From: David Margolis-Pineo
To: Barbara Barhydt; Helen Donaldson
CC: Gregory Vining; Jeremiah Bartlett; Philip DiPierro; Tom Errico
Date: 2/3/2016 12:34 PM
Subject: Review Comments for 65 Munjoy St

Memo To: Nell Donaldson
Barbara Barhydt
From: David Margolis-Pineo
Re: 65 Munjoy St – Eight Unit Residential Unit

The Department of Public Works has the following final review comment for the above project.

TYPICAL DRIVEWAY CONSTRUCTION OUTSIDE OF RIGHT OF WAY
NOT TO SCALE

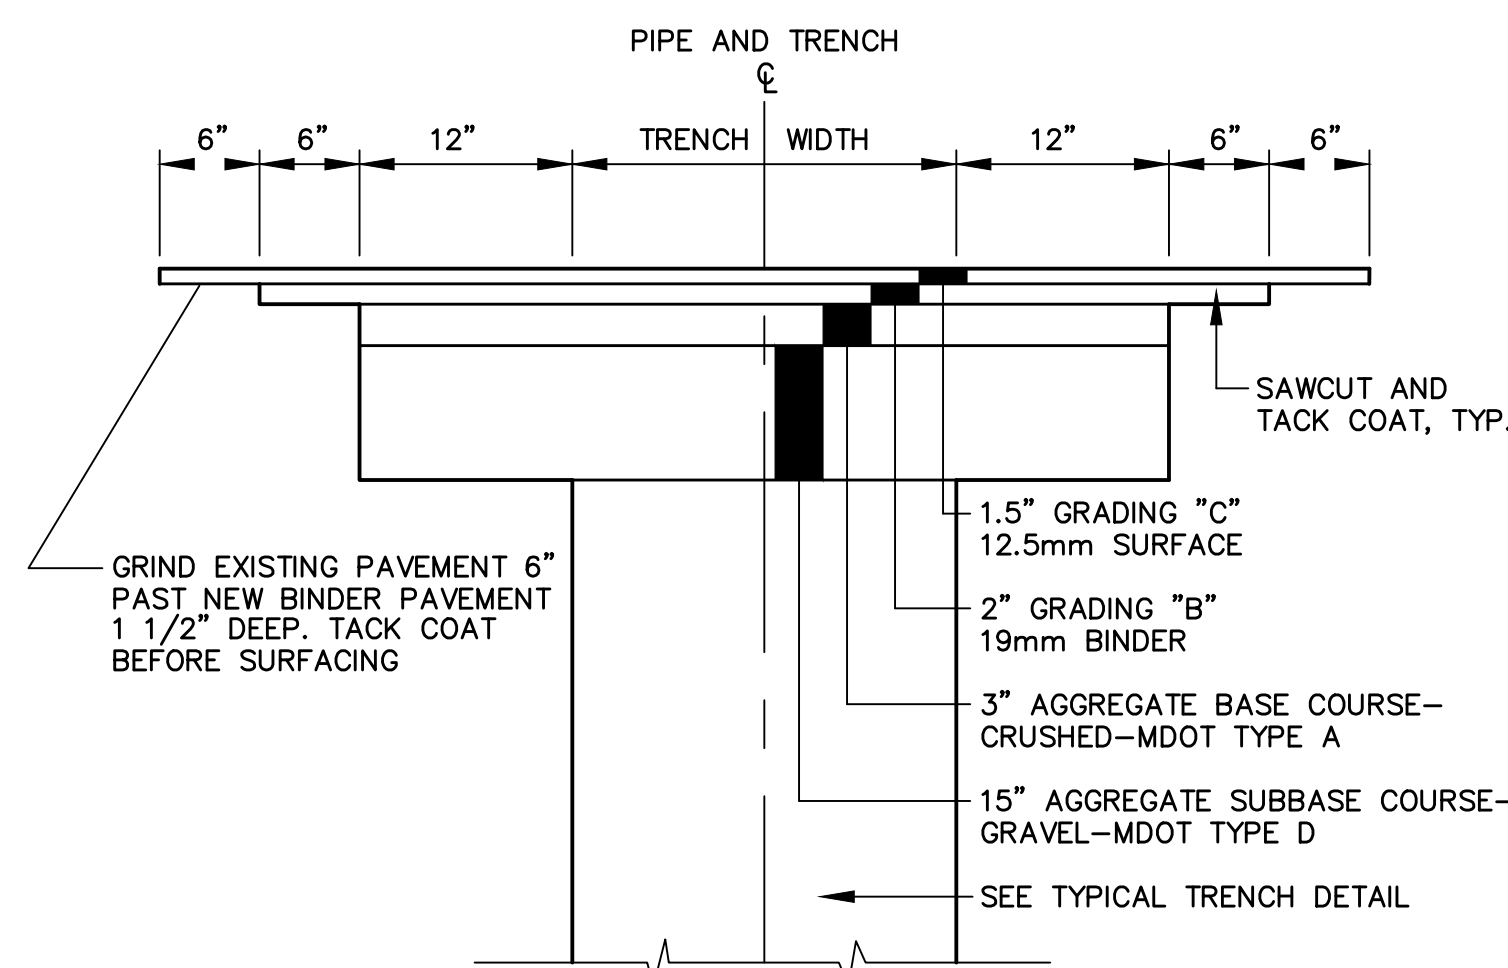
1. The applicant is required to execute an easement or license with the City of Portland for access, grading and landscaping by the applicant on City property.
2. The applicant has proposed a brick driveway apron which does not meet the City's driveway apron material policy. If the applicant is agreeable to an agreement that the applicant will be responsible for maintaining the brick apron, this Department is supportive of waiving the material policy for this project.
